## Honeycutt Hills Community - Lot 20

Townsend Model – Elevation 1

### 2<sup>nd</sup> Floor Framing — Rear 10' x 8' Sliding Glass Door Header

M+K Project #: 126-23047

2ND FLOOR FRAMING PLAN

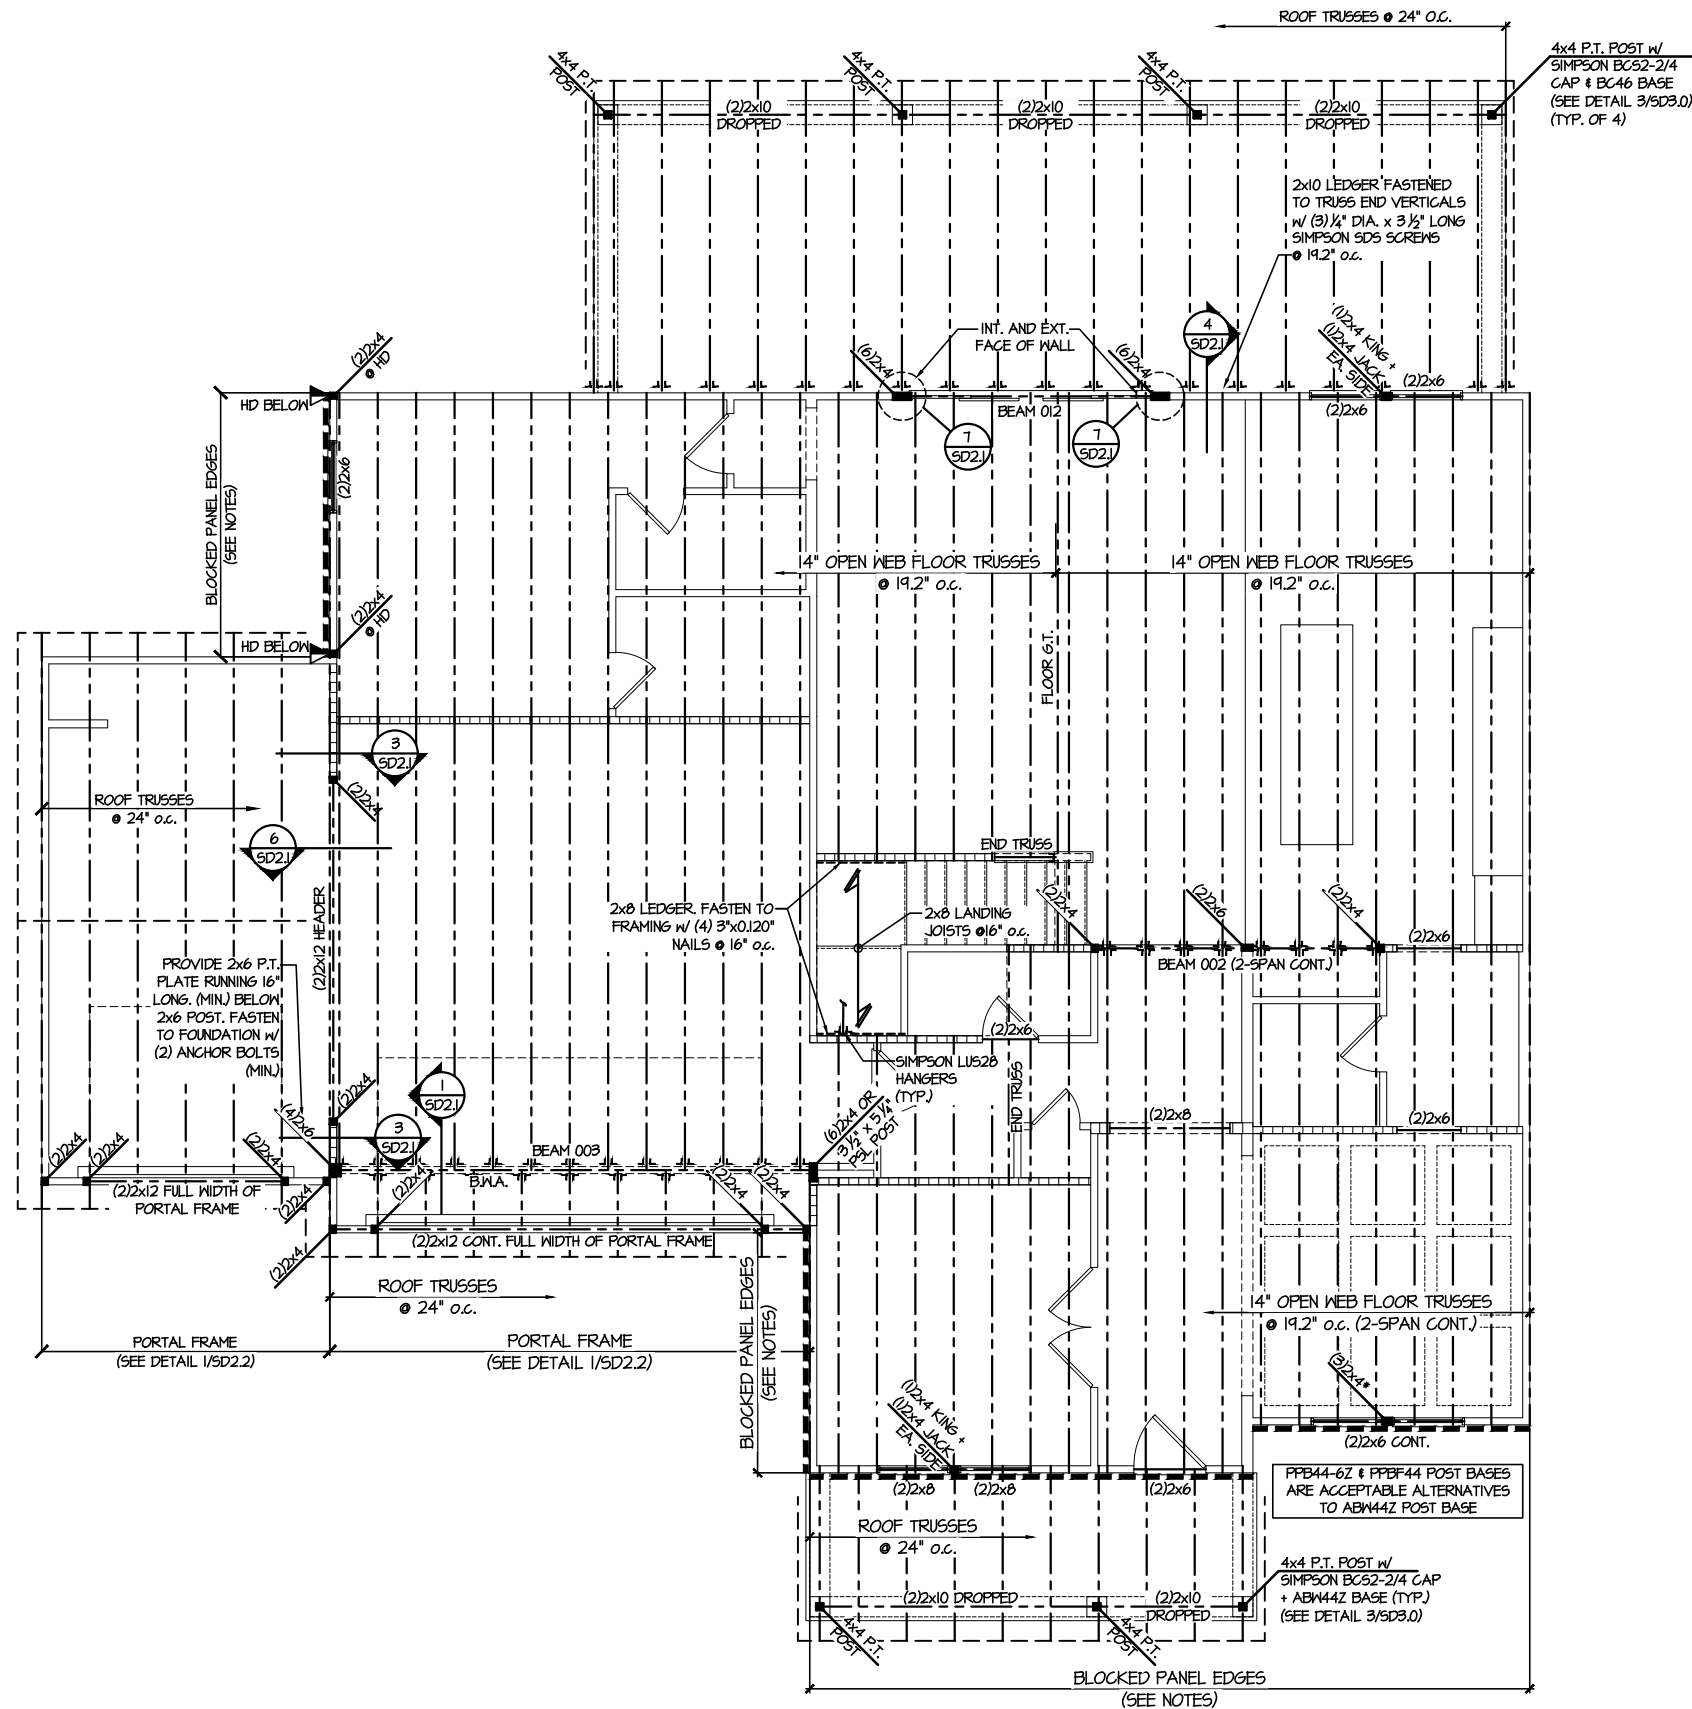
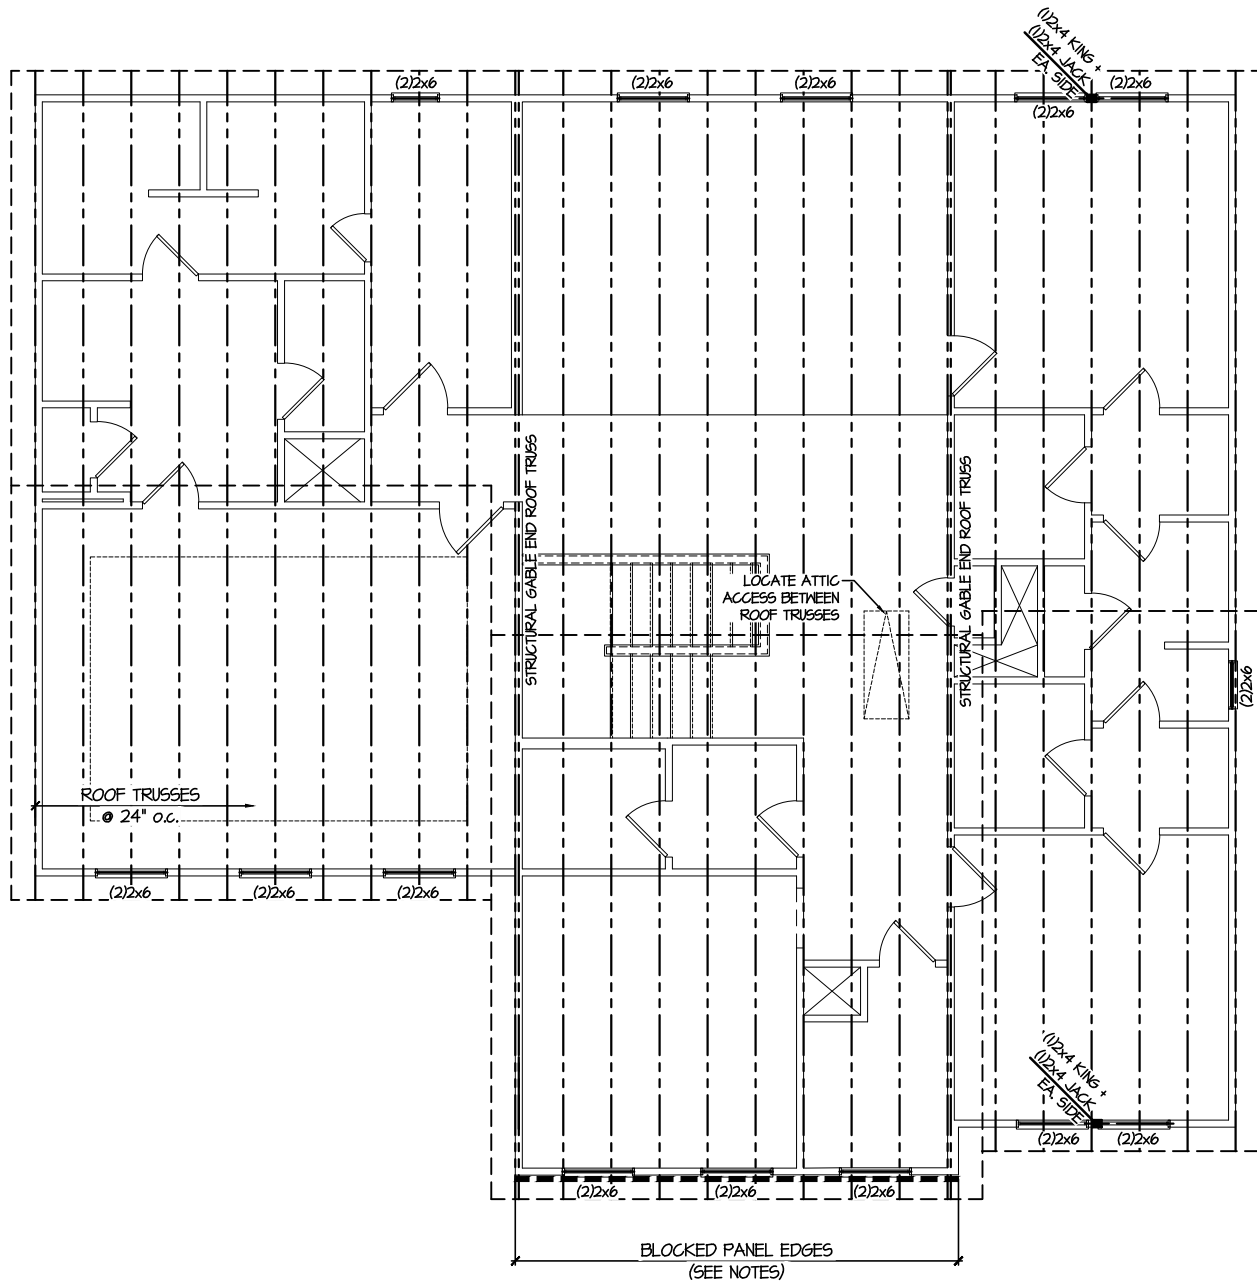
Pursuant to your request, we have prepared this letter to address the 2<sup>nd</sup> floor framing plan at the rear 10' x 8' sliding glass door header. It was reported to us, by you, that with the (2) 1 3/4" x 14" LVL header that is called out on the structural plans there is not enough clearance to install the door below.

We have analyzed the rear 10' x 8' sliding glass door header for a (2) 1 3/4" x 11 1/4" LVL in lieu of the (2) 1 3/4" x 14" LVL that is called out on the structural plans, and it is our professional opinion that the shallower 11 1/4" header is adequate to support the code required loads. The existing header may be removed and replaced with the shallower sized header. Alternatively, the bottom of the existing header may be notched for the installation of the door as required (2" maximum). Contractor is to start notch at corner of door opening below with a 1" diameter hole drilled prior to making straight cuts. Contractor must not over cut notch. Existing horizontal straps shall be removed and adjusted to new depth of notched beam. Provided additional blocking as required for adjusted horizontal strap connection.
